Kirklees Flood Management & Drainage (Lead Local Flood Authority) – Statutory Consultation

Consultation on Application Number: 2018/91661

Proposal: Land at Walkey Terrace and Brunswick Street, Heckmondwike

Comments

| Drawing Title:  | SITE PLAN - OPTION 4 AS PROPOSED                                 |

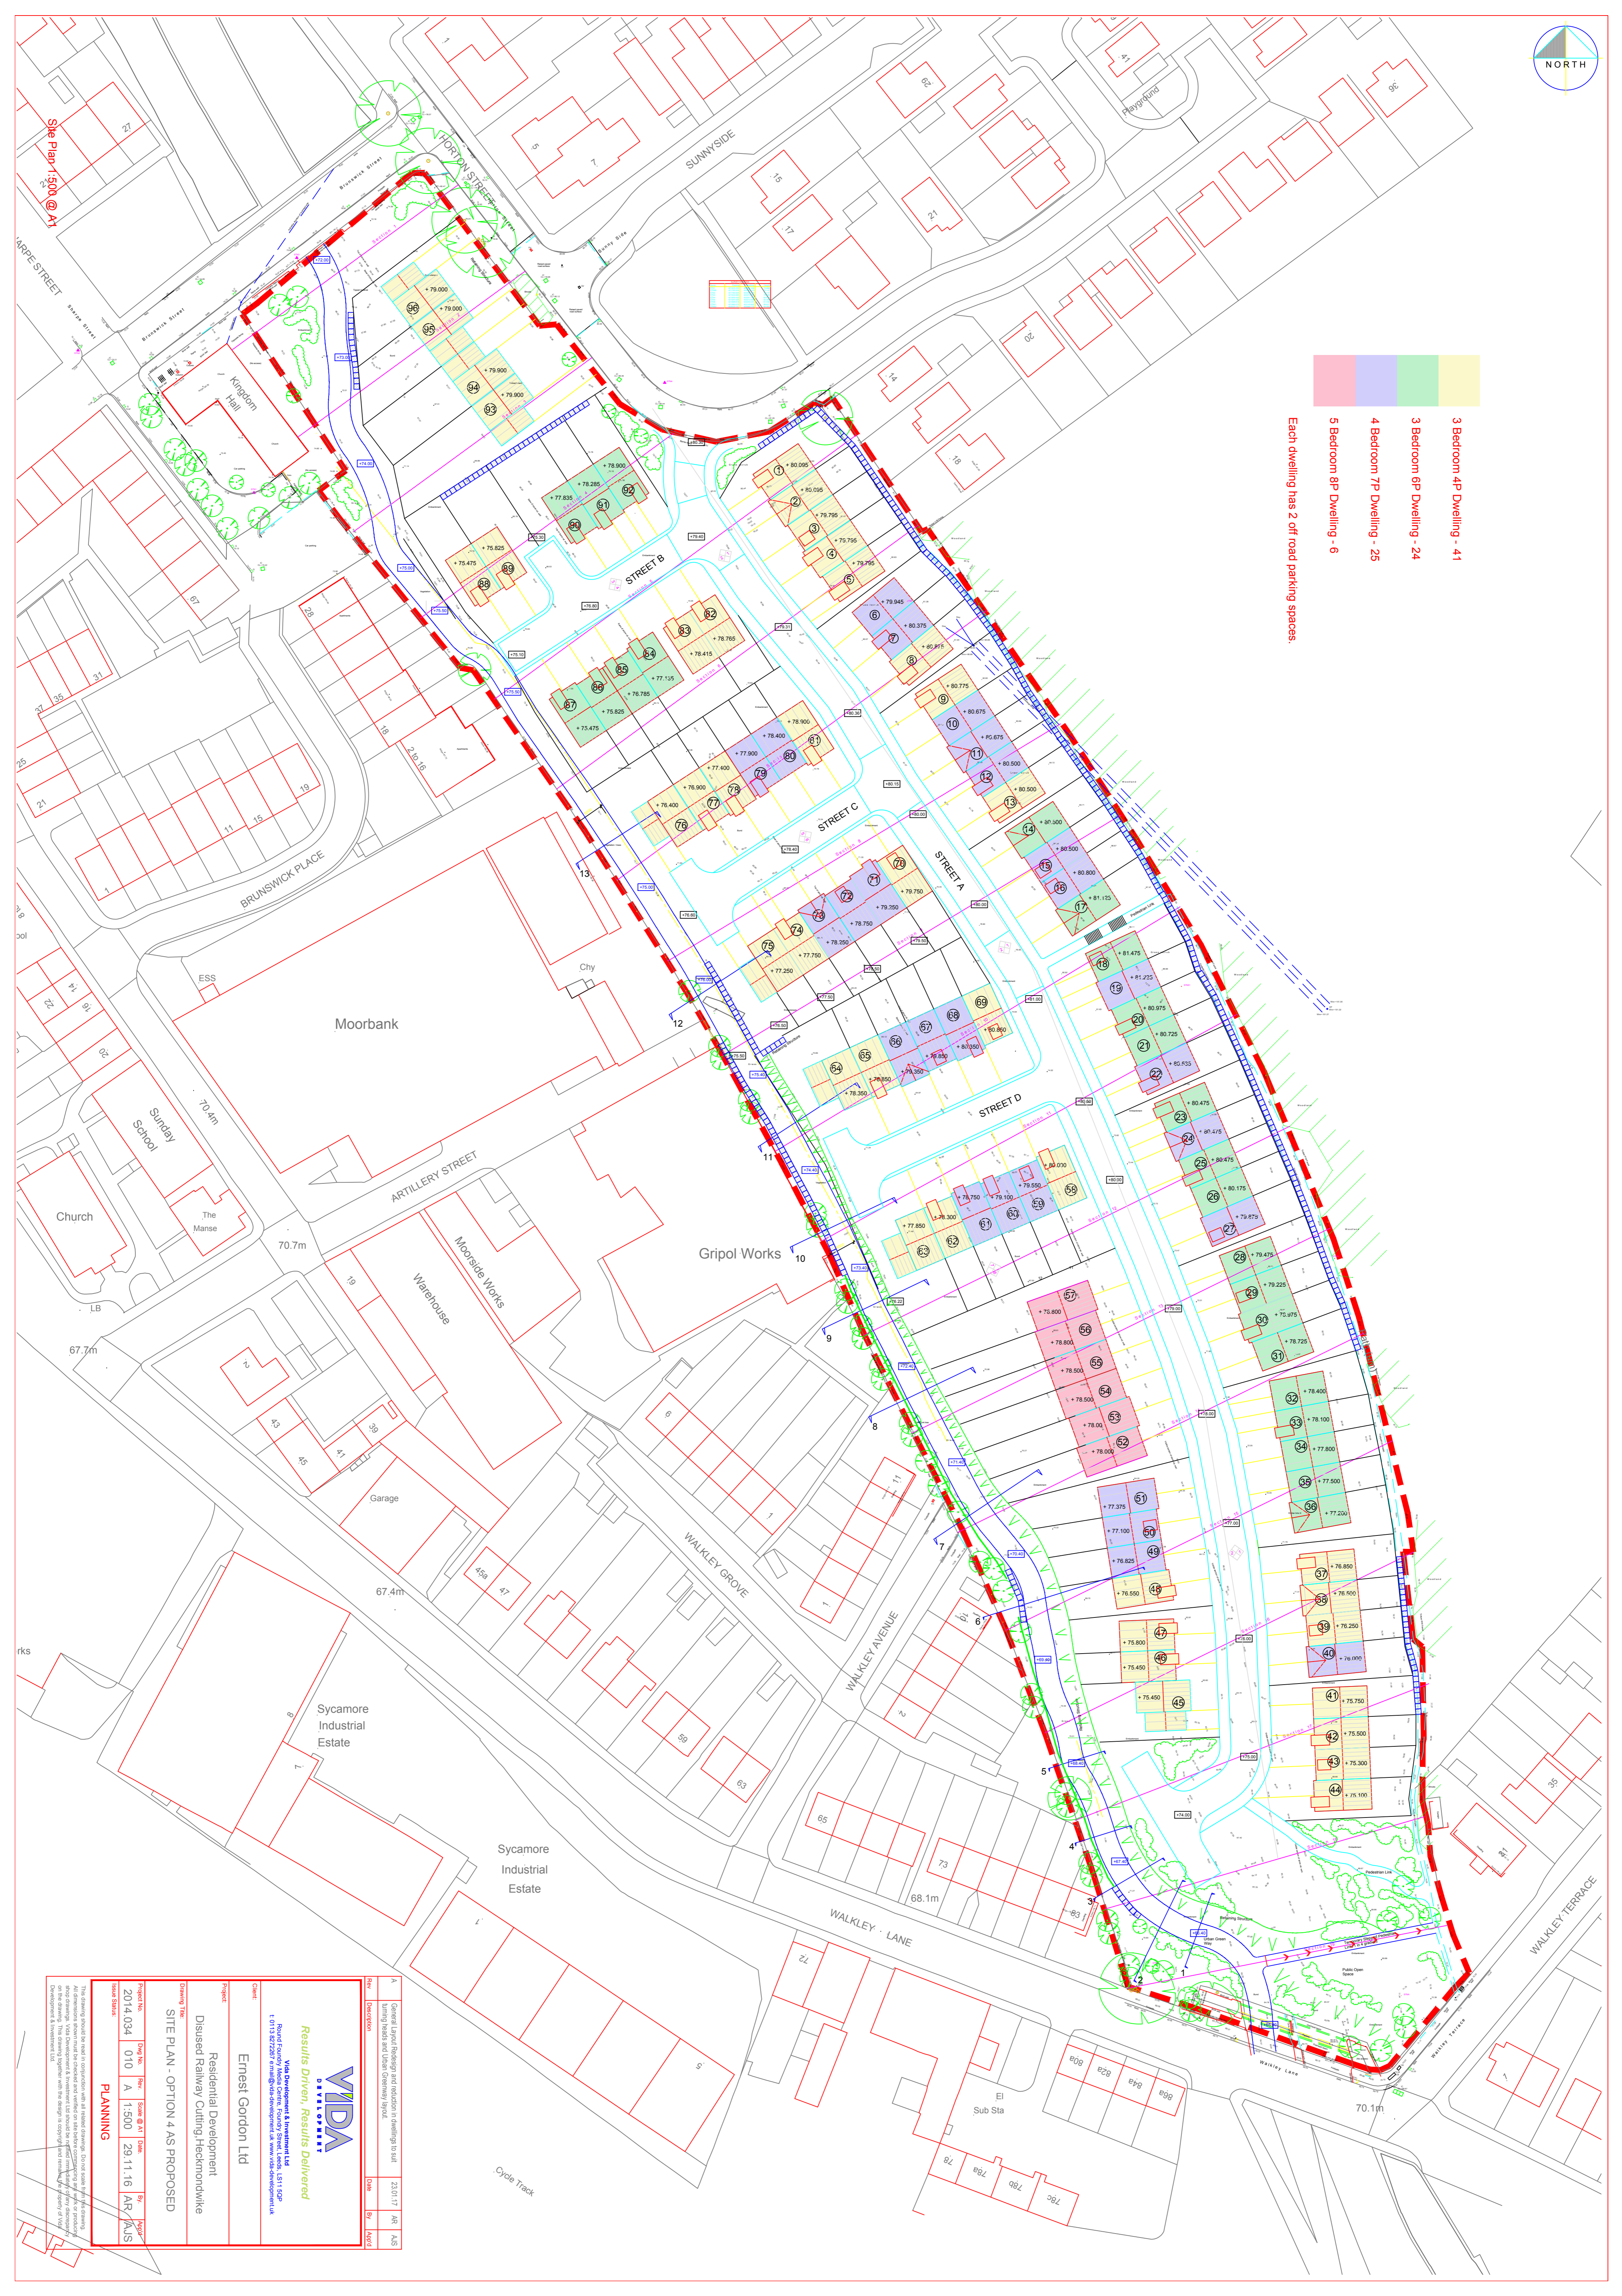
An estimate of storage requirements and how and where these will be placed in the indicative layout plans is required, remembering that structures 1500mm or greater under the highway may preclude adoption agreements being signed with the Council.

The site is subject to catchment surface water routes as well as on site flood routing through the design. The estate road is shown to fall toward properties at a lower level. A discussion around driveways falling to the road to create a through conduit is required.

Long sections for flood routing should not only be considered for the road but for the valley created to the bottom of the 'western' properties gardens. The flood risk assessment should describe areas of ponding and its safety and how property and curtilage should be avoided.

Section 8

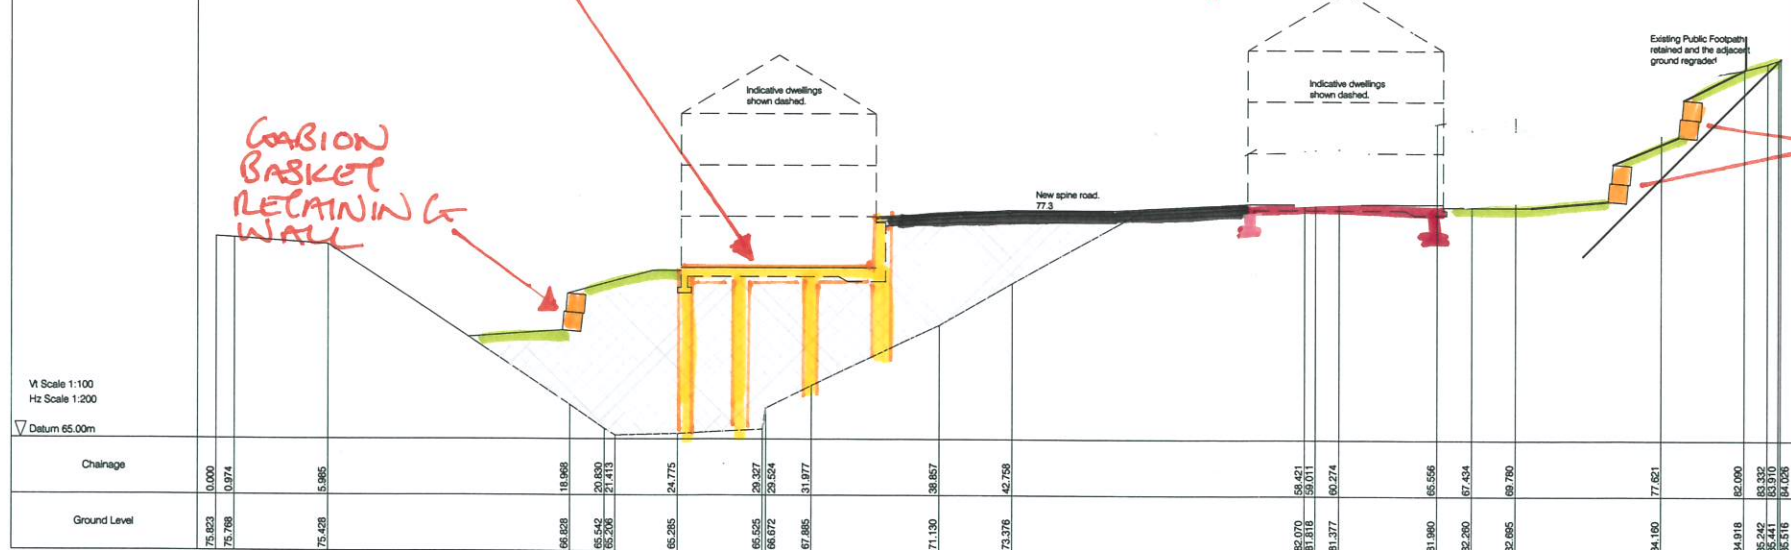
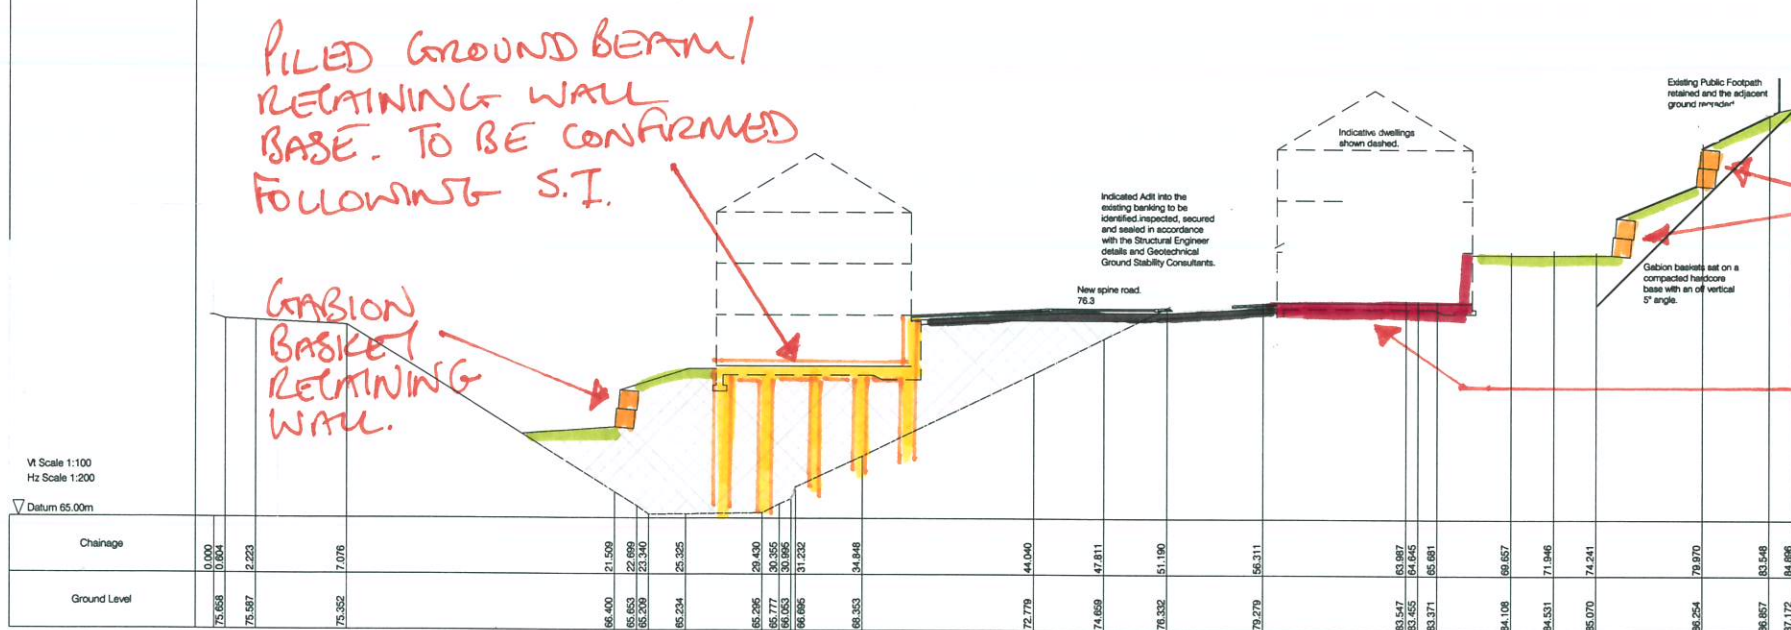
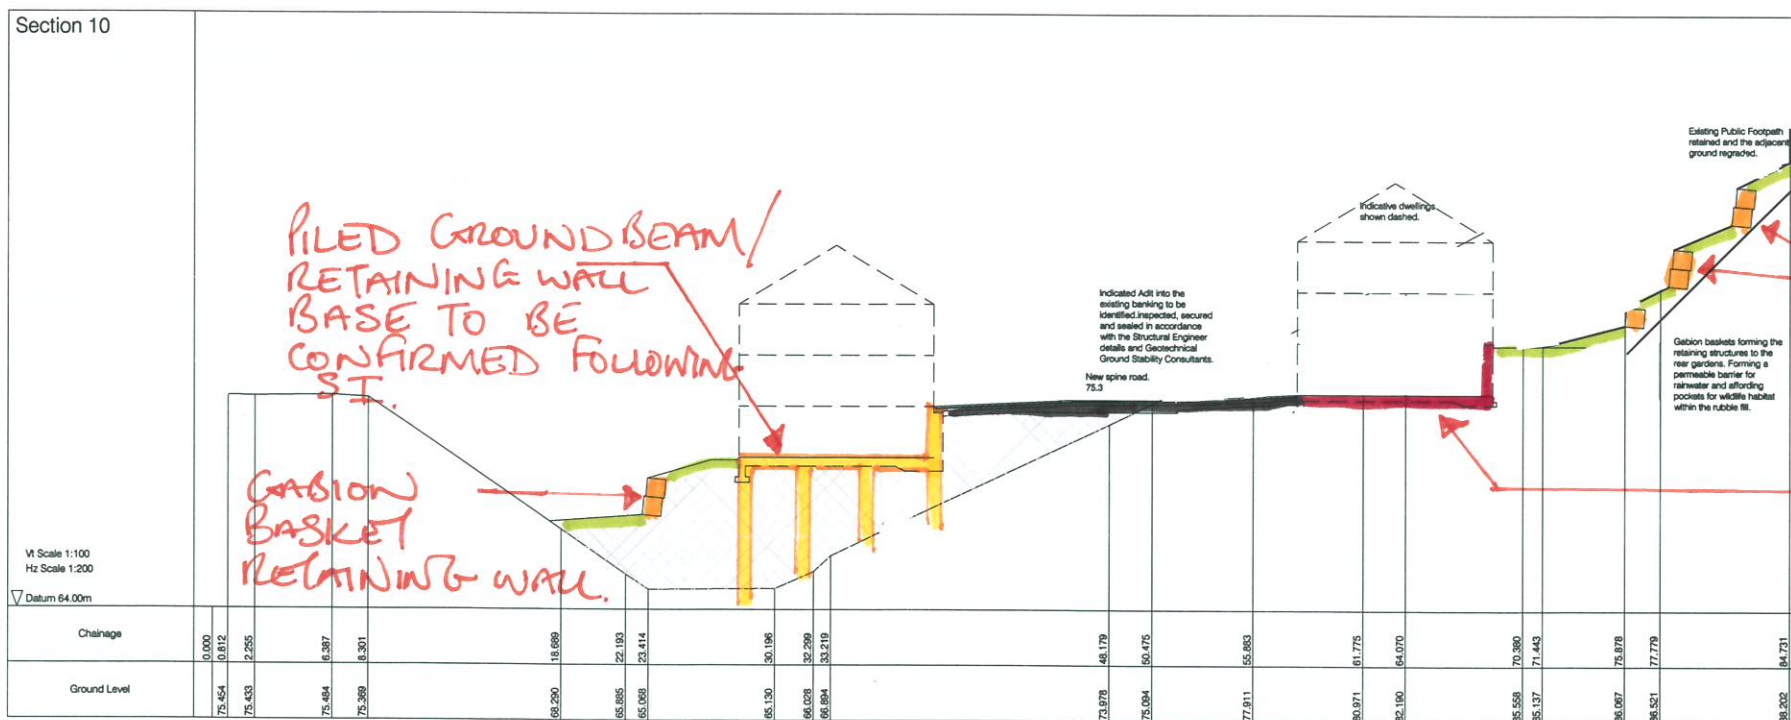
Land drainage to filled sections has to be considered at regular intervals as compaction takes place.

Land drainage for the toe of embankments should be considered. All these require outfalls (see above for acceptability).
